Planning V2 Review
1. On the bottom right of ALL pages please have the following text: County File Number: PPR2224

SITE DEVELOPMENT PLAN
CONSTITUTION STORAGE

PPR2224: 6855 constitution Ave. Mini Warehouse
Review #2 - 7/28/22

SITE DEVELOPMENT PLAN

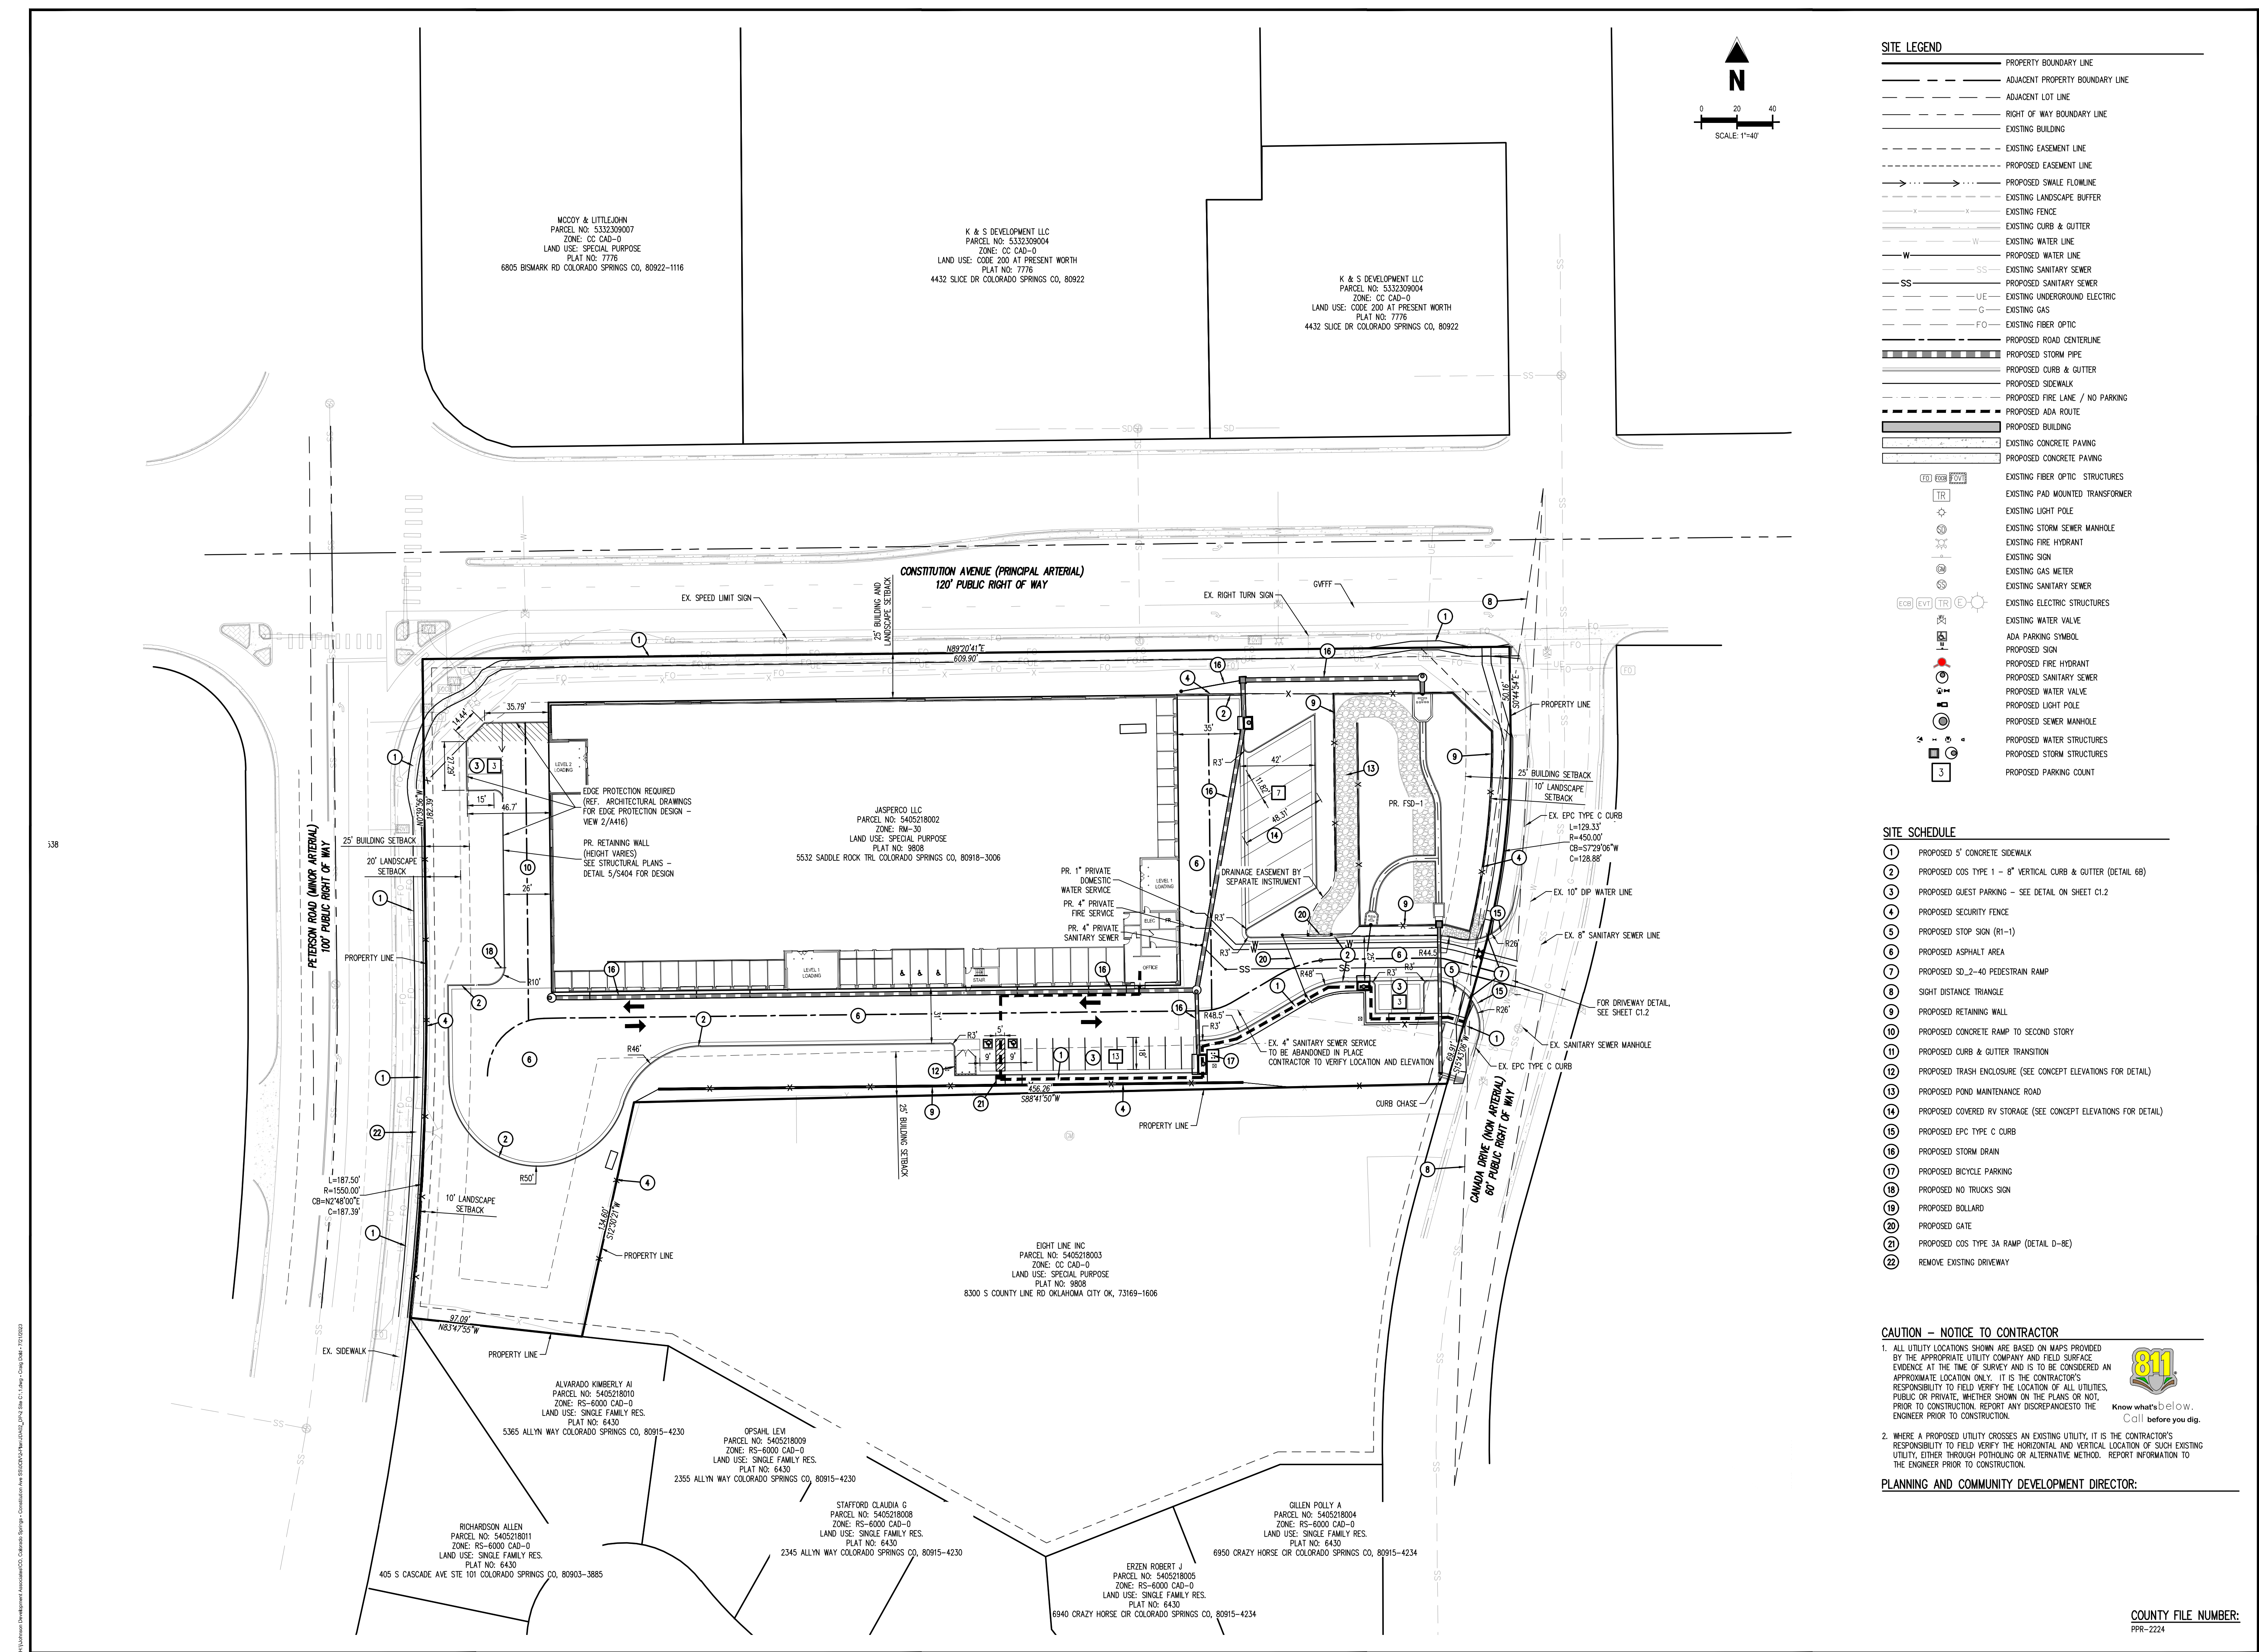
Not Addressed: Where trucks are expected to turn around, please show the turning radius and the max size truck (with an unskilled driver) that can use the turn around.

Not addressed: Loading areas shall be designed so that a maneuvering or parked delivery vehicle will not obstruct any parking or drive aisles used by employees or customers. The south and west elevation has storage unit doors right next to the drive aisles, please demonstrate that the lanes are wide enough for two way traffic and a parked truck. This also seems to be a safety hazard to have a door accessing a drive aisle.

What is the security fence for if there are no doors or windows on this entire side? Please remove on the front if it is not needed and add more landscaping

Please provide documentation that excludes trees from being planted in this area due to underground utilities

This looks like a truck turn around area - what are the dimensions?
Planning can't support this change if it reduces the landscaping below the required amount.

Do trucks pull into this loading dock? if so, show a detail.

LANDSCAPE PLAN

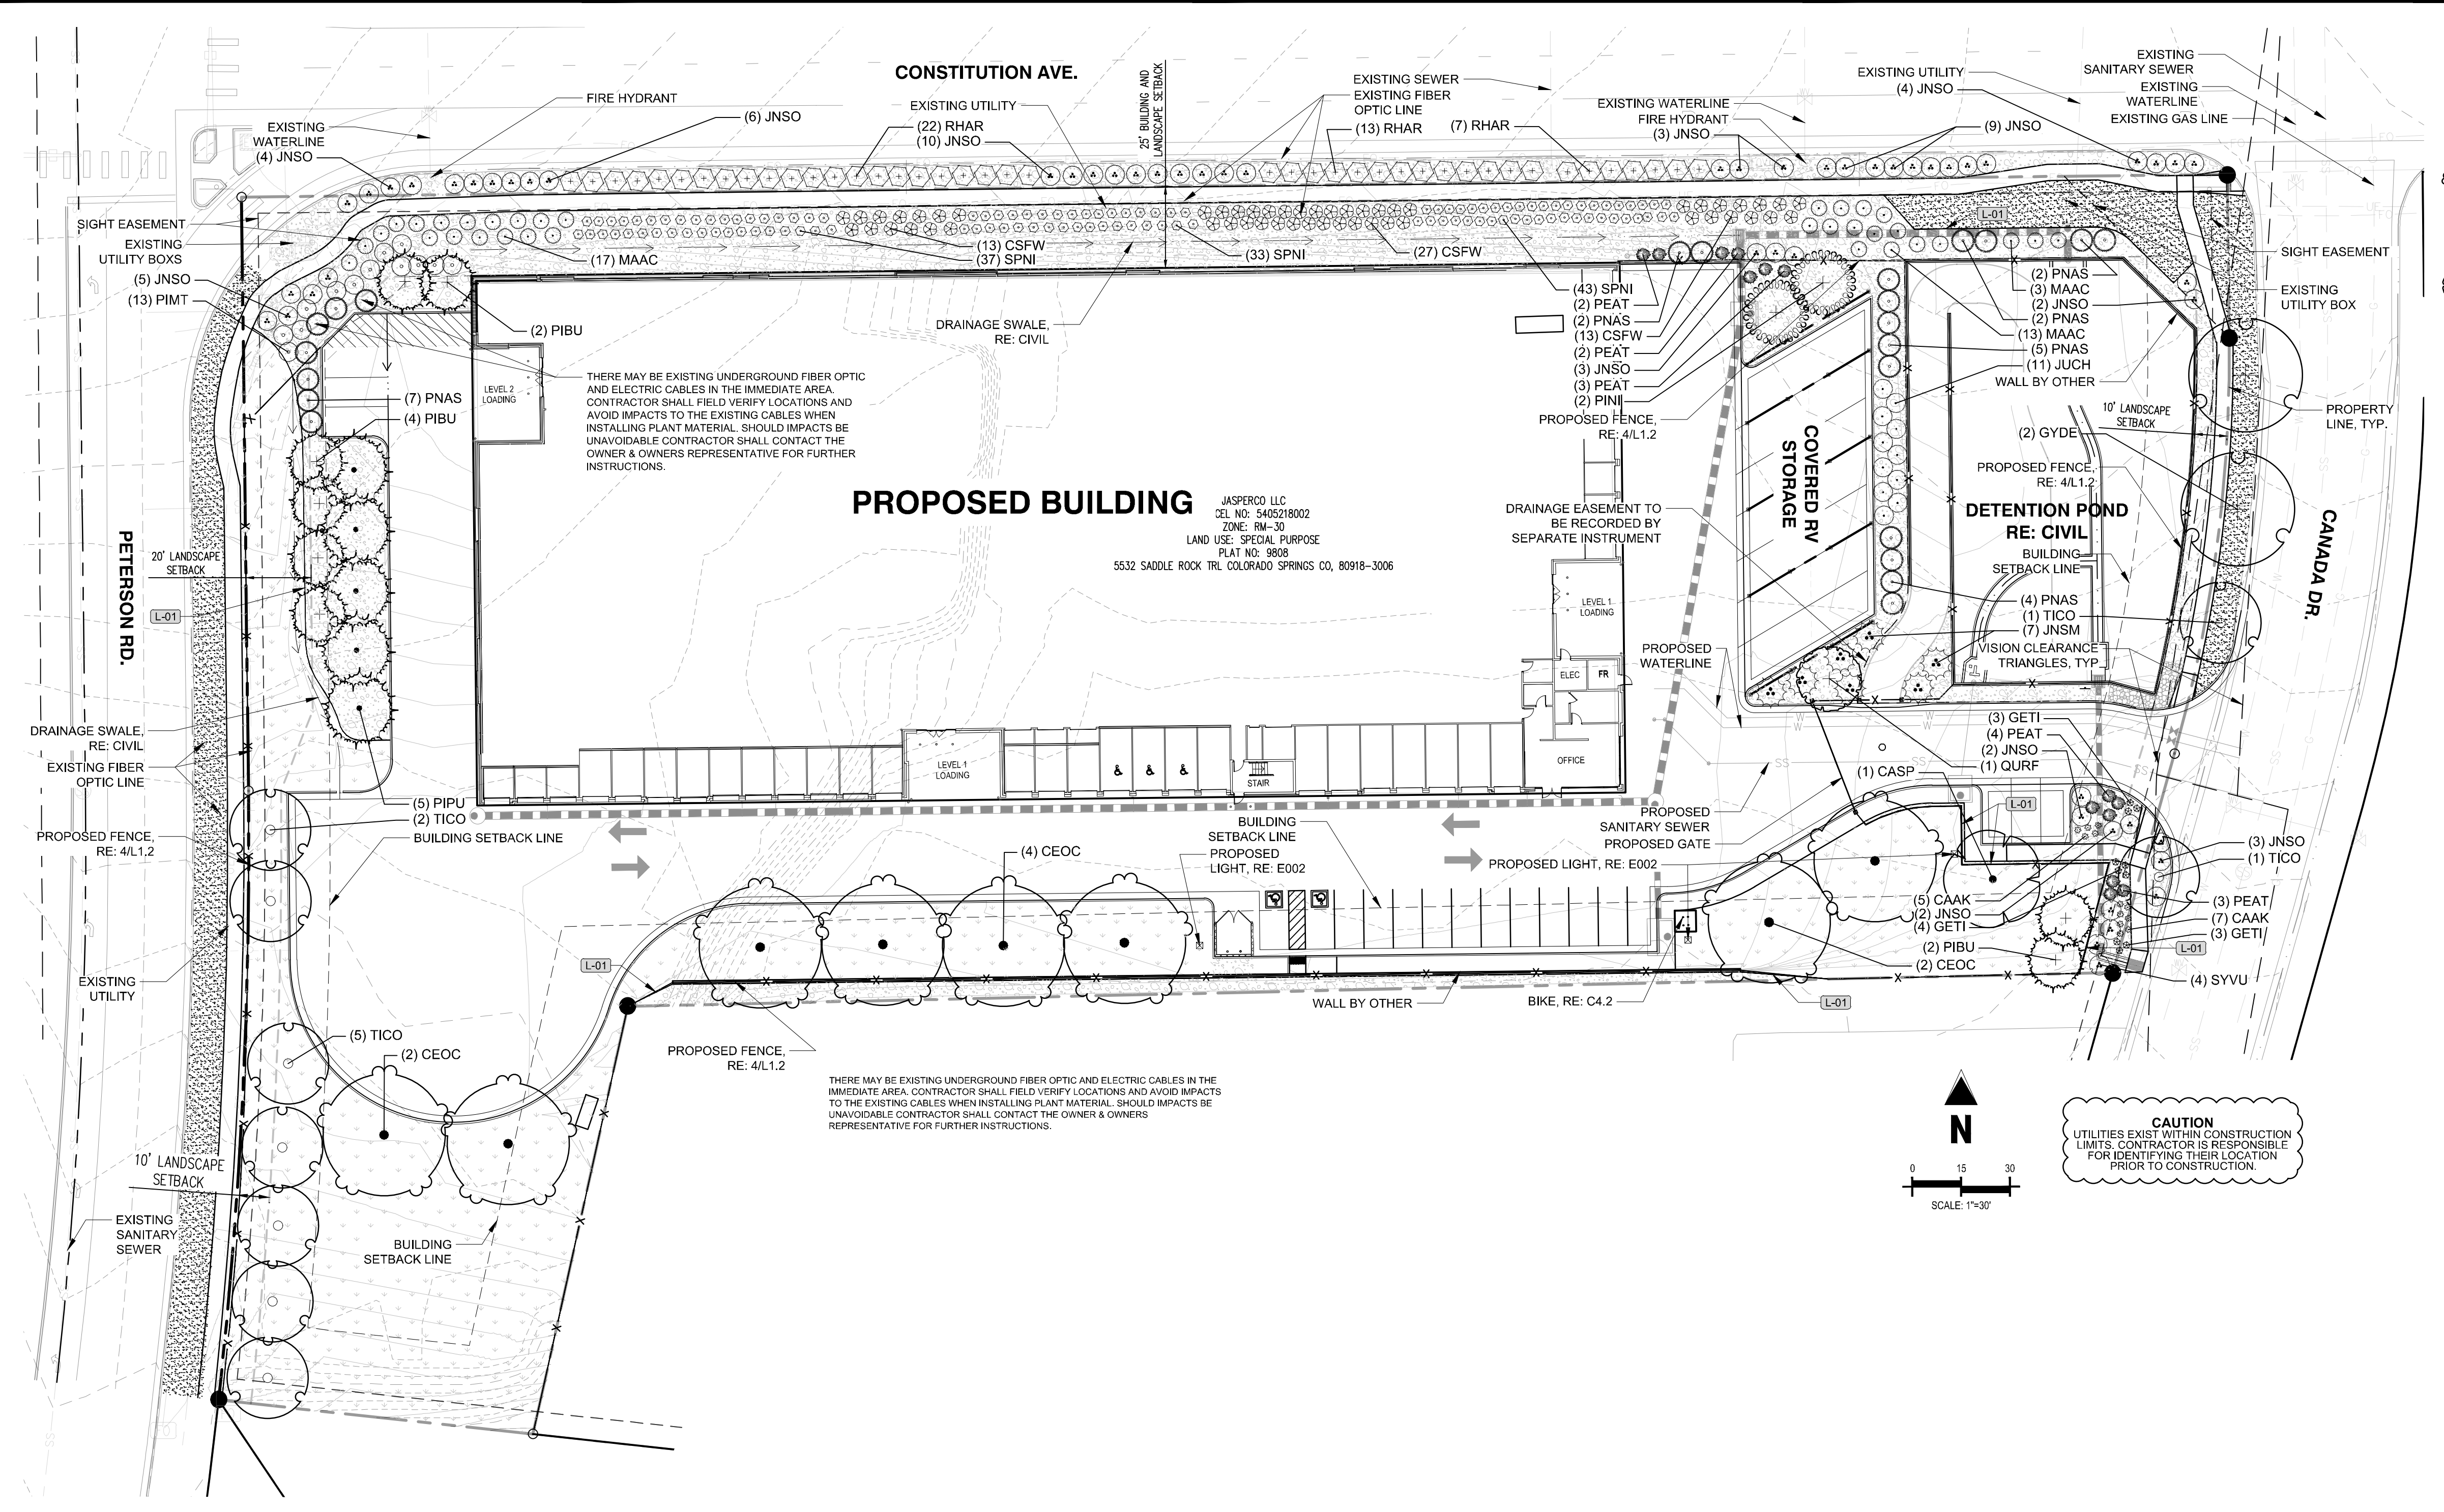
Not Addressed: Loading bays need to be screened from view from public road or residential areas - screening shall meet code requirements. The loading dock on the NW corner and is not 100% screened - on the landscape page. The landscape screening has now been reduced because the driving area was increased. Please amend.

NOTE: SCREENING OF THE LOADING DOCK HAS BEEN PROVIDED USING A COMBINATION OF EVERGREEN TREES AND SHRUBS. WHERE POSSIBLE TREES HAVE BEEN USED, HOWEVER WHERE UTILITY CONFLICTS EXIST LARGE EVERGREEN SHRUBS HAVE BEEN PROVIDED INSTEAD OF TREES.
